**Re: Part 3A Major Development Project  
Kmart Warehouse and Distribution Centre, Eastern Creek (MP 10\_0082)**

We advise that we have been authorised by **Epiross Pty Ltd (PO Box 85, Westgate, 2048)** to act on their behalf to forward this written submission in response to your letter (signed) dated 26/07/10 in regard to the above proposed development (identified as Project Number MP 10\_0082).

Reference is made to the Traffic Impact Report prepared for Australand by Road Delay Solutions, dated June 2010, which forms part of the documentation submitted with the development application. The following comments and concerns are noted:

Figure 6: Year 2016 AM Projected Vehicle Movements

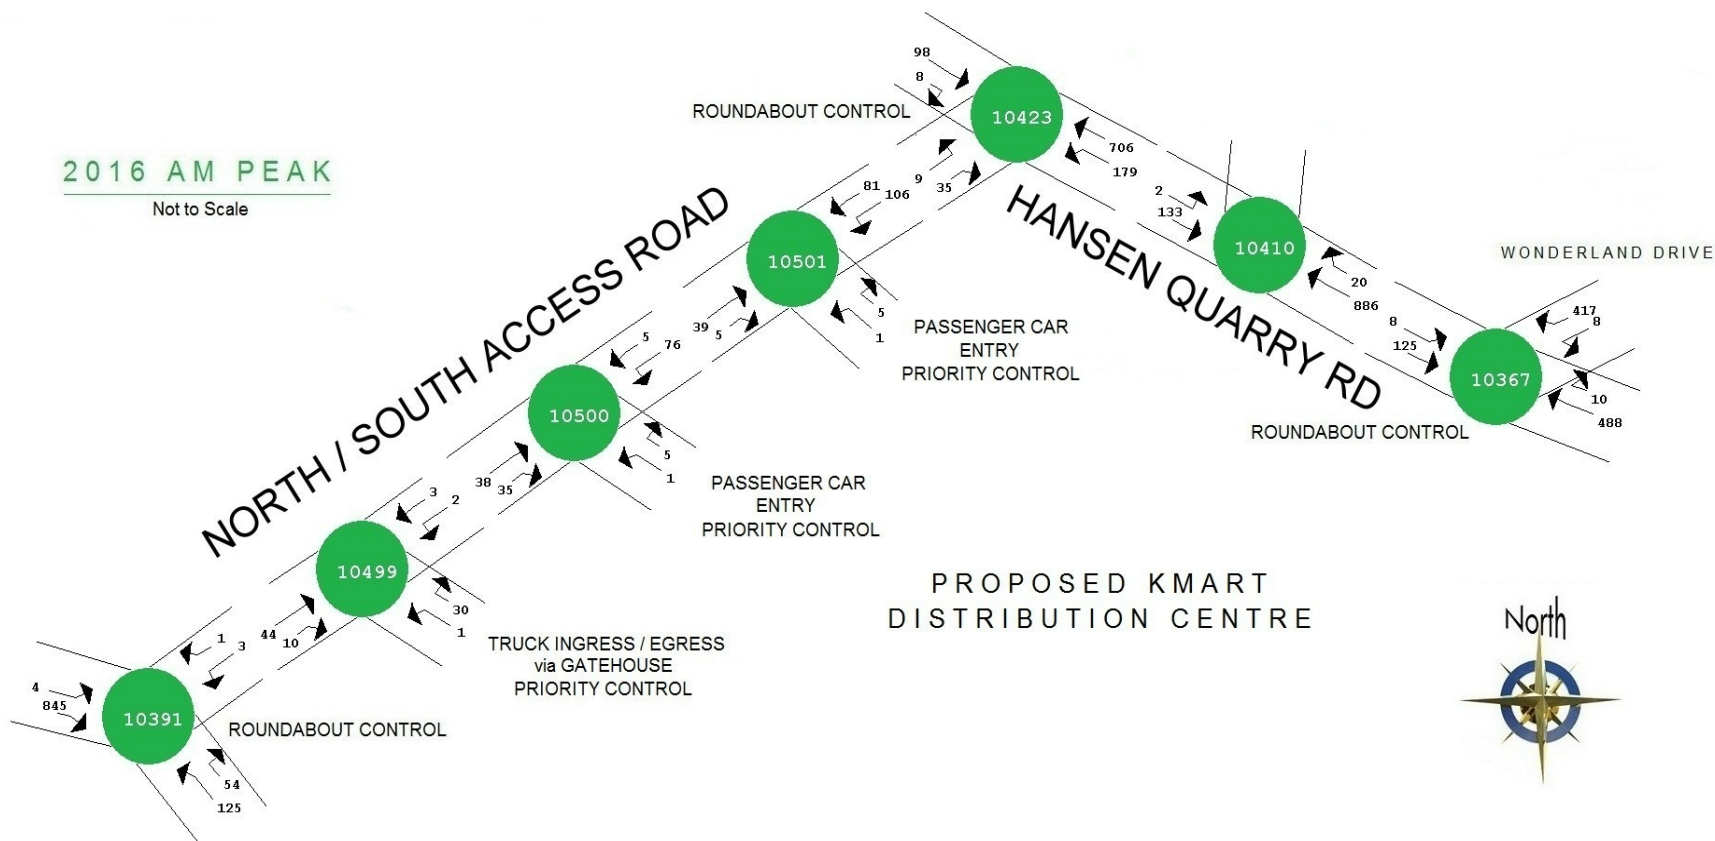
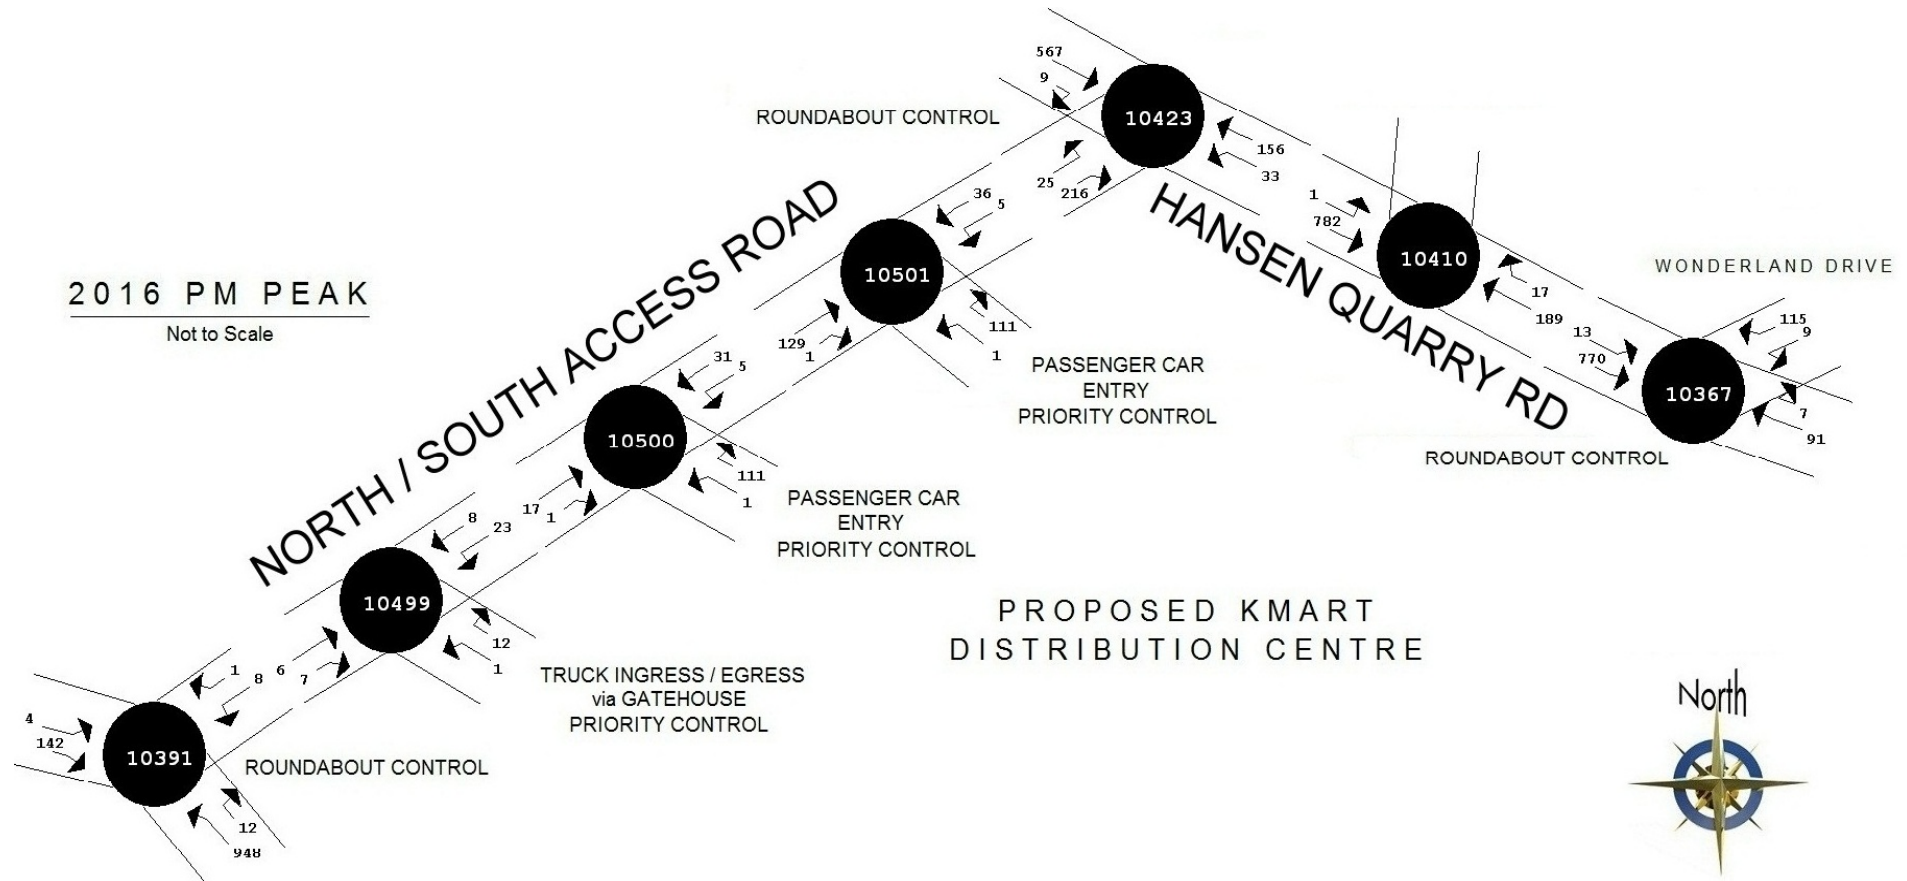
- The report assesses the traffic impacts based on the planned road infrastructure anticipated for year 2016 and not the infrastructure that will be available at the time when the Epiross and Kmart developments will be initially operational. The report highlights that *'given the vast disparity between the existing conditions at the site and the planned development of the precinct, it is considered prudent to afford Council the opportunity to comment on the relevance and/or location of any existing traffic counts'*, and *'this report utilizes projected count information taken from strategic modeling of the Eastern Creek Precinct for the future year 2016'*. In this light, it is felt that it will be necessary to assess the traffic conditions based on the infrastructure and anticipated traffic counts that will be present at the time when Epiross and Kmart developments will be initially operational (years 2011-2012).

- The report notes that the projected peak traffic volumes and flows are considered as 'conservative' estimates (in accordance with RTA requirements and their 'Guide to Traffic Generating Developments'), with the roundabout controlled intersection of 'Hansen Quarry Road' and 'Access Road B' expected to operate at a satisfactorily level of service in the interim period (years 2011-2016).

Figure 1: Projected Interim Peak Hour Traffic Flows

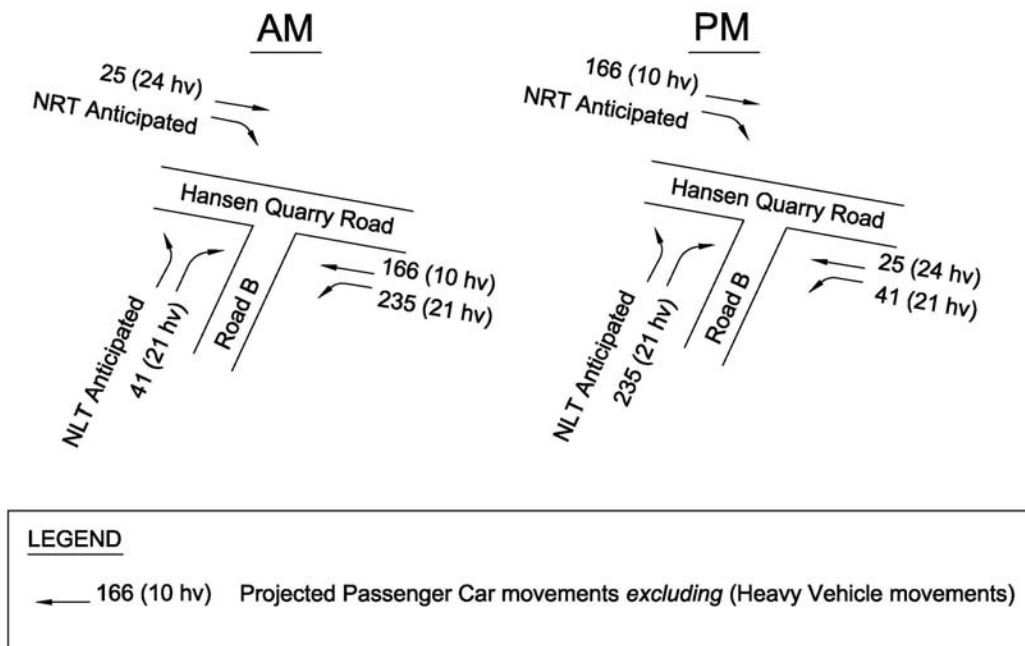
- Whilst the above comment is acknowledged, there is still a main point of concern relating to the 'Access Road B' for Kmart that will become the only point of access and egress for the Kmart generated traffic during the interim period (years 2011 to 2016). It is noted that this North-South access road will in the interim terminate at the Southern end of the Kmart development. This will require for all the Kmart generated traffic to access the precinct's road infrastructure via the roundabout controlled intersection of 'Hansen Quarry Road' and 'Access Road B', which is located between Epiross entry & egress

gates to their development. The Kmart outbound traffic entering the roundabout will have right of way and this will present serious bottleneck and delays concerns to Epiross outbound/egress (Eastbound) traffic during peak times, especially during the PM peak.

- Epiross position is that if the projected traffics volumes and flows are exceeded during the interim period (years 2011-2016), and/or if there is further development along the 'Access Road B' which requires all generated traffic to access the precinct's road infrastructure via the roundabout controlled intersection of 'Hansen Quarry Road' and 'Access Road B', this will potentially cause major delays for Epiross outbound/egress (Eastbound) traffic during PM peak time, and subsequent disruption to their business operations.

- In light of the above scenario, Epiross feel that it would be necessary for Blacktown City Council to either:
  - bring forward the enforcement of provision of further road infrastructure development to the South of the 'Access Road B', which will then link this roadway to the Old Wallgrove Road and provide an alternate means of access/egress for traffic generated from the Kmart (and other) developments located along this 'Access Road B', and hence relieve the congestion and delays at the roundabout controlled intersection of 'Hansen Quarry Road' and 'Access Road B', or

- undertake major capital works to convert the intersection of 'Hansen Quarry Road' and 'Access Road B' from roundabout controlled to signalised controlled, in order to provide a better and more efficient flow of traffic to all legs, especially during PM peak time.
